# KITTITAS COUNTY

### MEMORANDUM

TO: Community Development Services  
FROM: Candie Leader, Administrative Assistant *cl*  
DATE: September 16, 2019  
SUBJECT: BLA BL-19-00013 (Bugni)

Please see below our comments regarding the Bugni Preliminary survey (BL-19-00013).

BUGNI PROPERTY

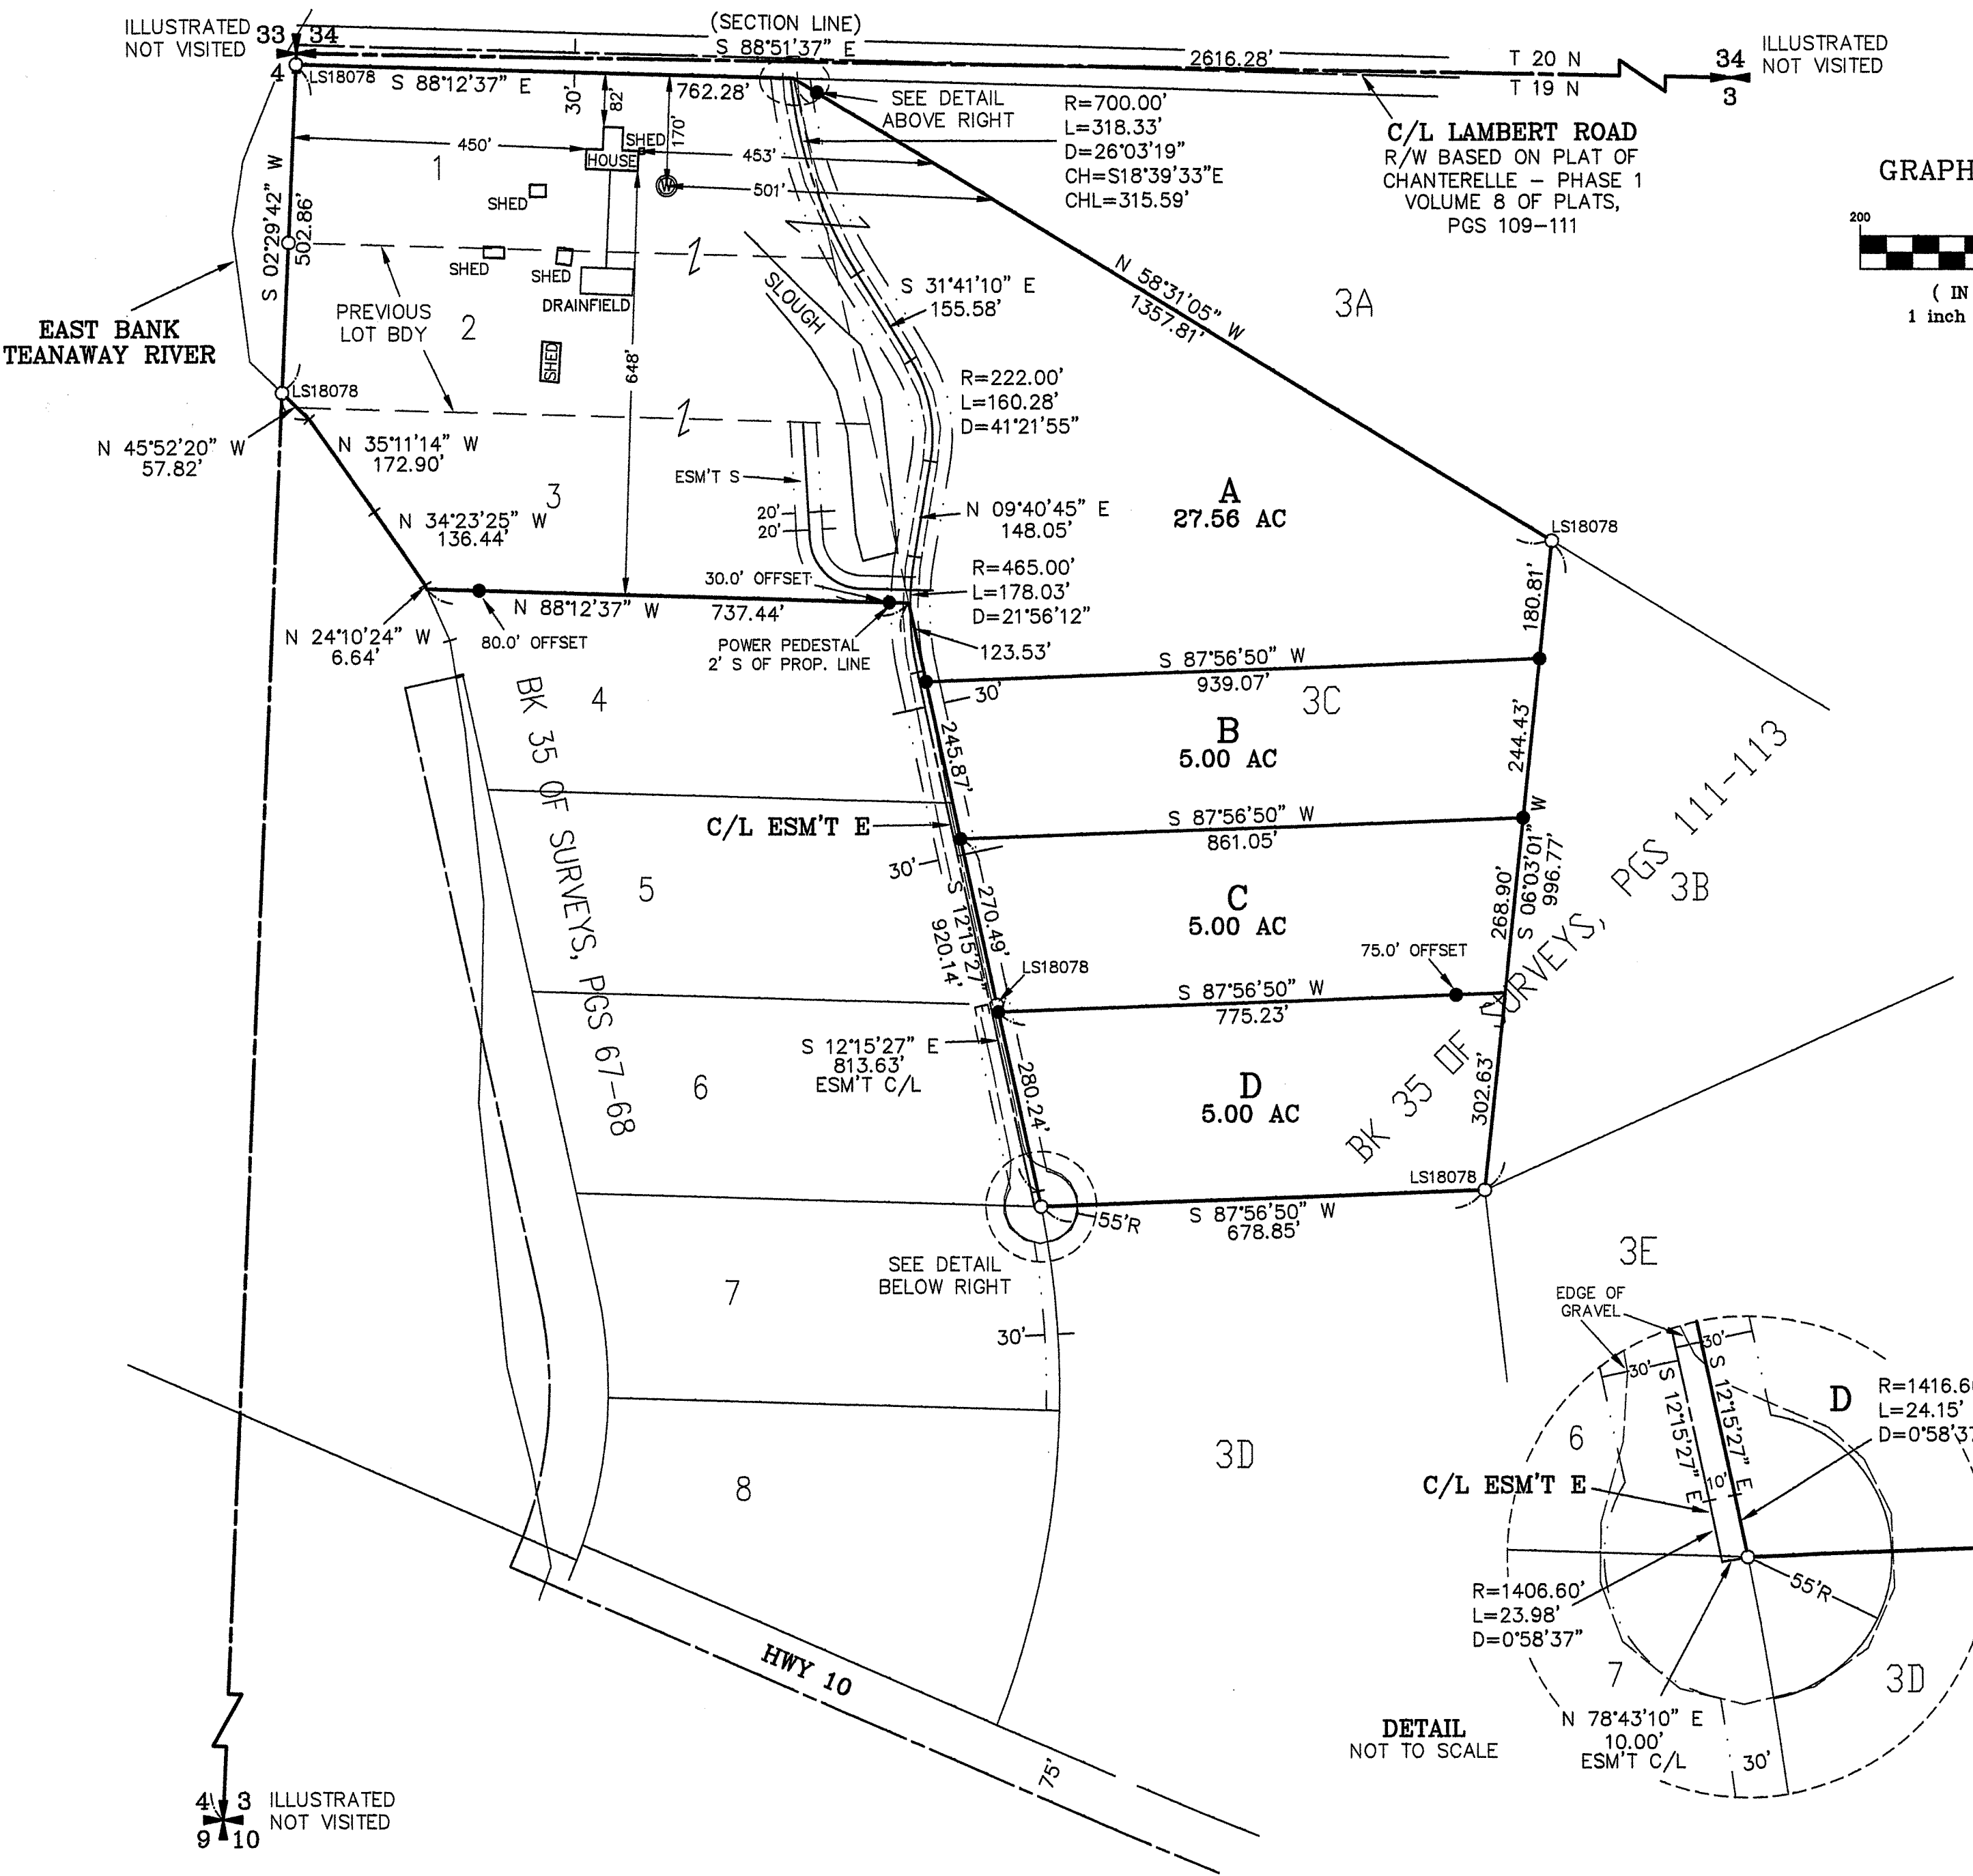
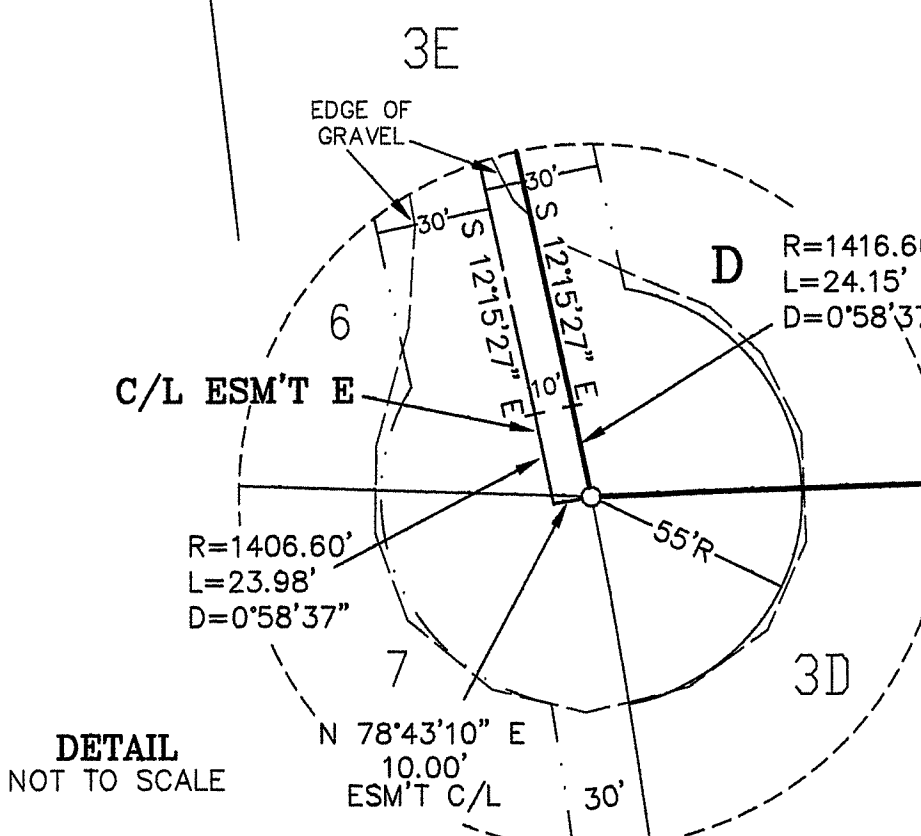
The survey detail of the access at Lambert Road appears to indicate the Bugni property line is 4.67 feet east of the centerline easement for "Easement E". The required private road right of way width is 60 feet. Do the Bugni's have an easement allowing full access of the 60 feet at Lambert Road?

1. Spelling of Northwest incorrect at top of page (both pages)
2. Include a distance tie from property to NW section corner.
3. Include a distance tie to the found corner located near the SW corner of Lot C.
4. Easement E as shown on sheet 1 should note "Created via separate document (or similar).
5. Easement E should include the purpose of the easement.
6. Easement S should note whether it is existing or to be created via separate document. If it is existing, the recording number should be referenced.
